WEST SUSSEX COUNTY COUNCIL CONSULTATION

TO:	Arun District Council FAO: Ms Myer
FROM:	WSCC - Highways Authority
DATE:	26 October 2021
LOCATION:	Butlins Upper Bognor Road Bognor Regis PO21 1JJ
SUBJECT:	BR/234/21/PL Rear extension to the existing temporary venue (Studio 36) to accommodate back of house facilities and associated works. This site is in CIL Zone 4 (Zero Rated) as other development.
DATE OF SITE VISIT:	n/a
RECOMMENDATION:	More Information
S106 CONTRIBUTION TOTAL:	n/a

Drawn: JD Approved: JULY 2021
Scale: 1:200 @ A1 PRINT SIZE
Sheet Description:
SITE LAYOUT PLAN
Sheet Number: IPL_21_363/12_101 Issue: 06-LPA

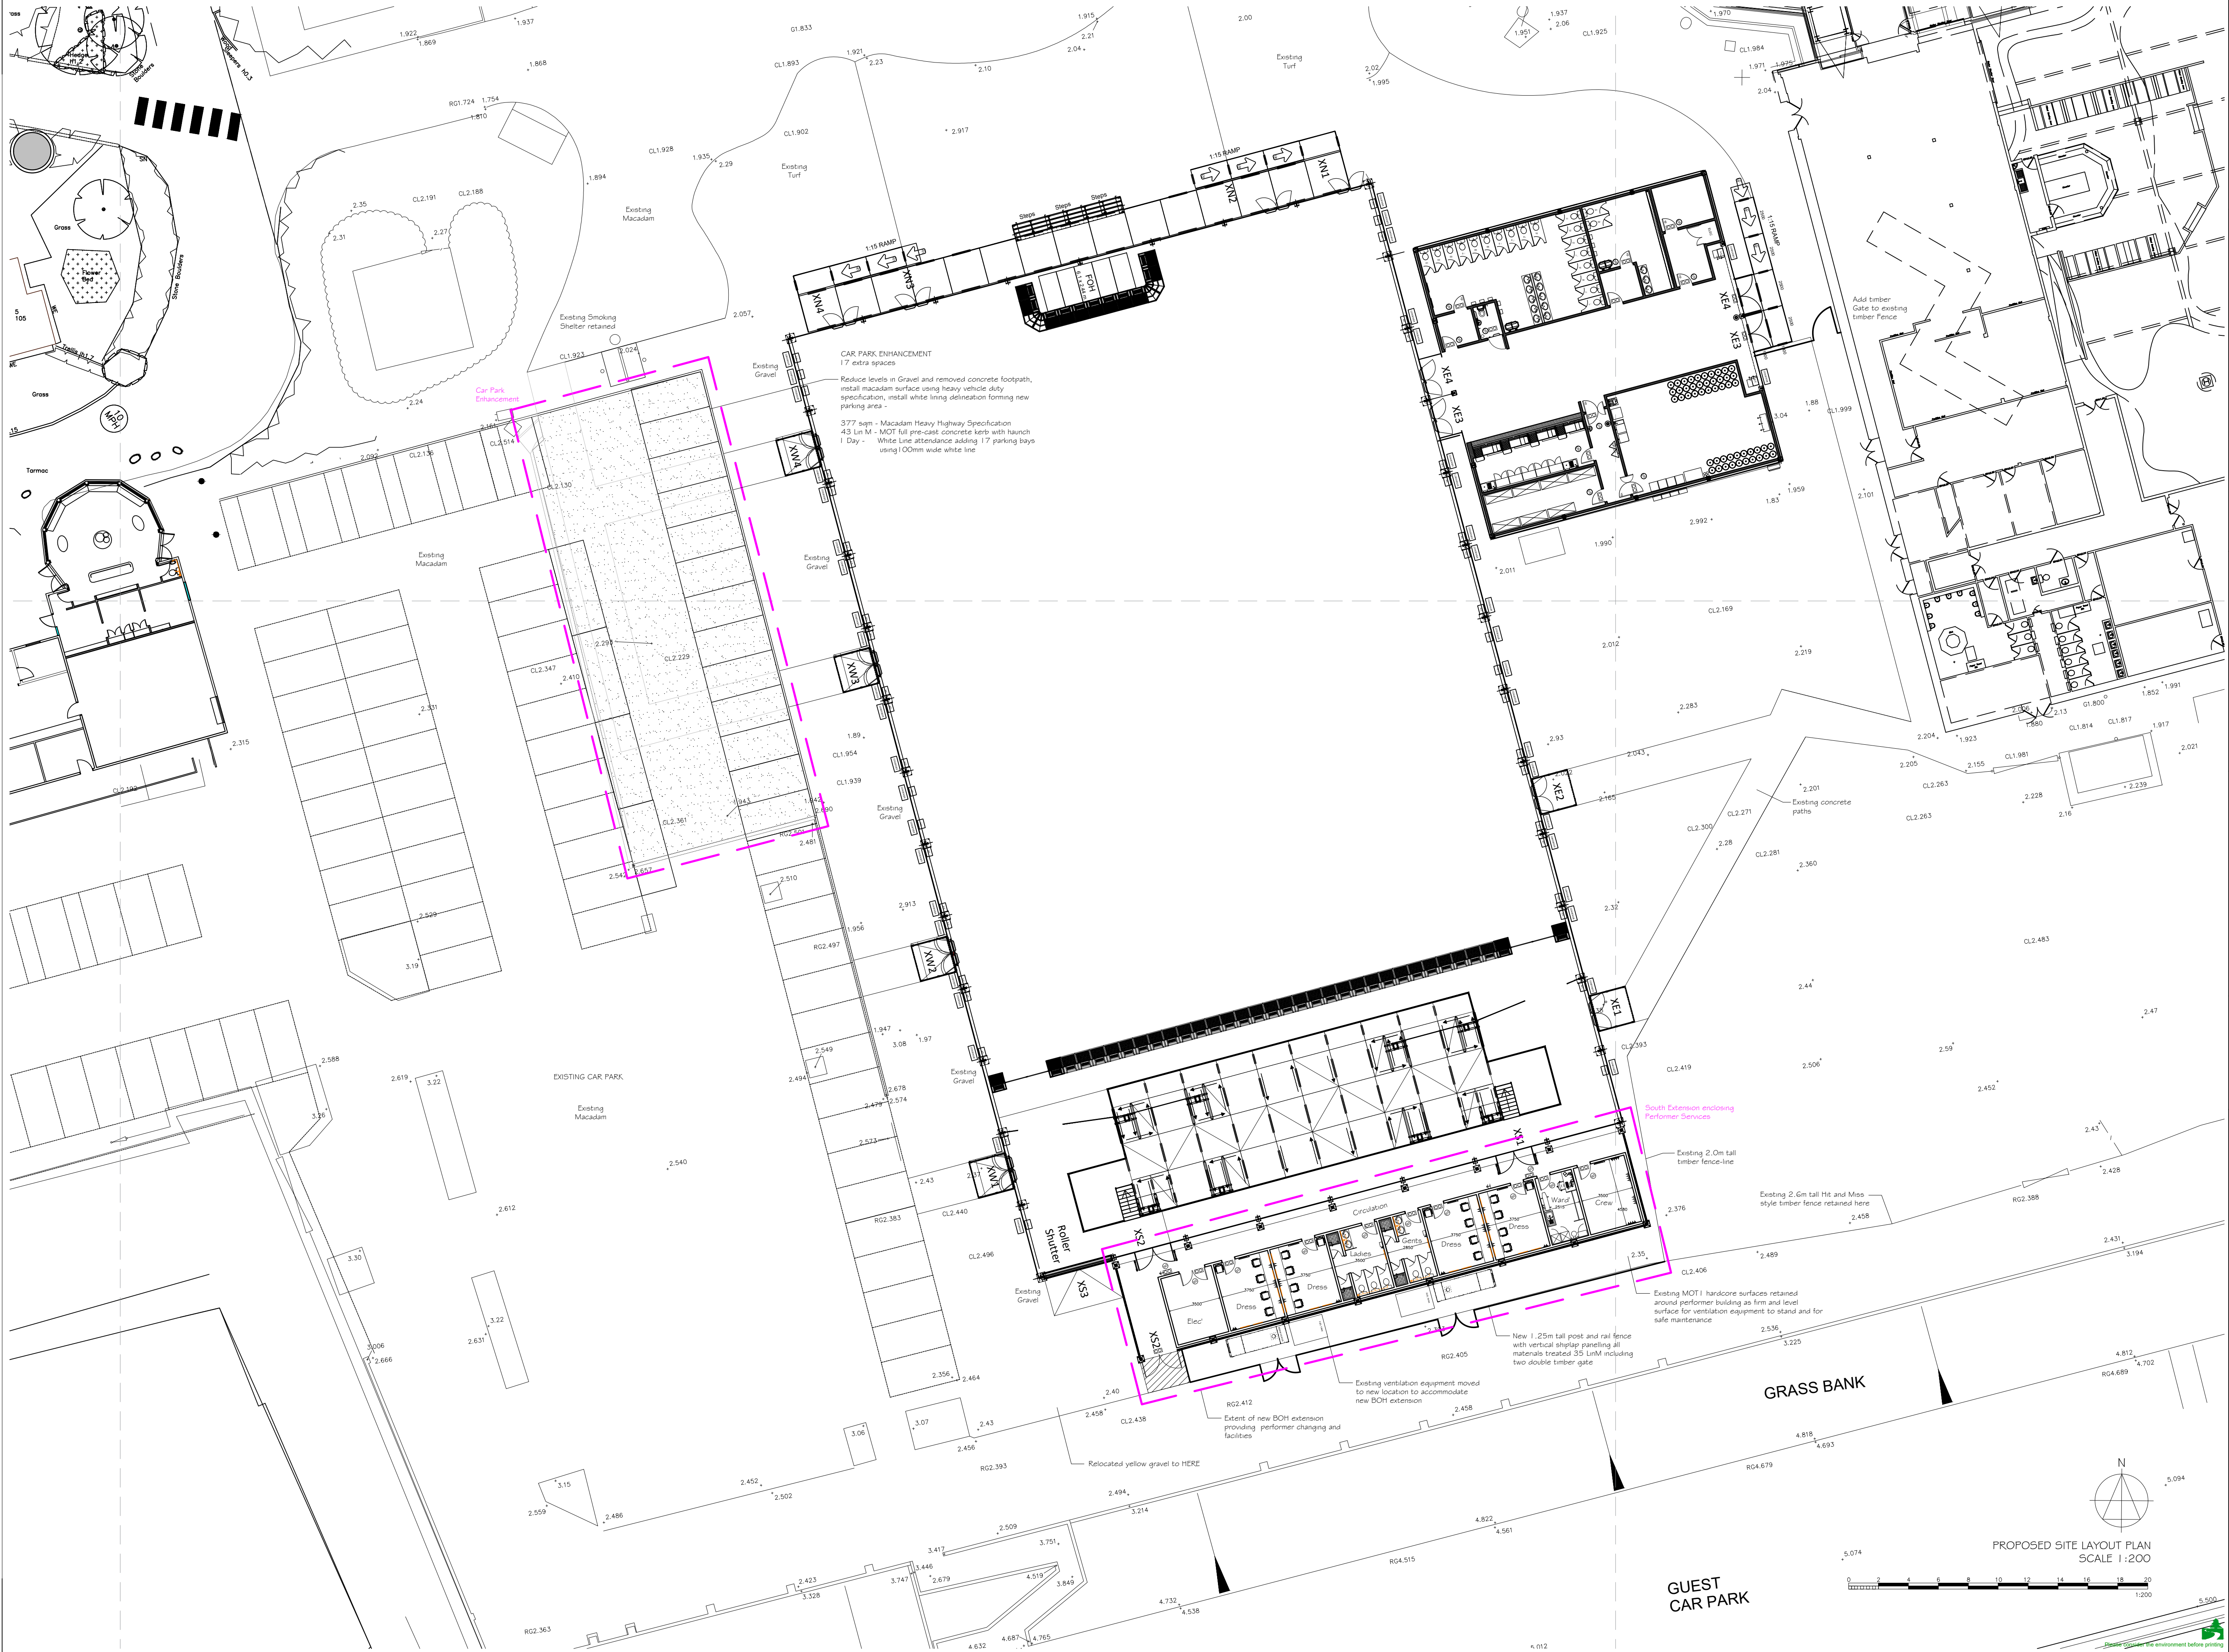
1. The LHA requests the applicant provides the anticipated trip rate for both the existing and proposed.
2. The applicant has not provided justification to the parking provision. The LHA requests the applicant provides such details.
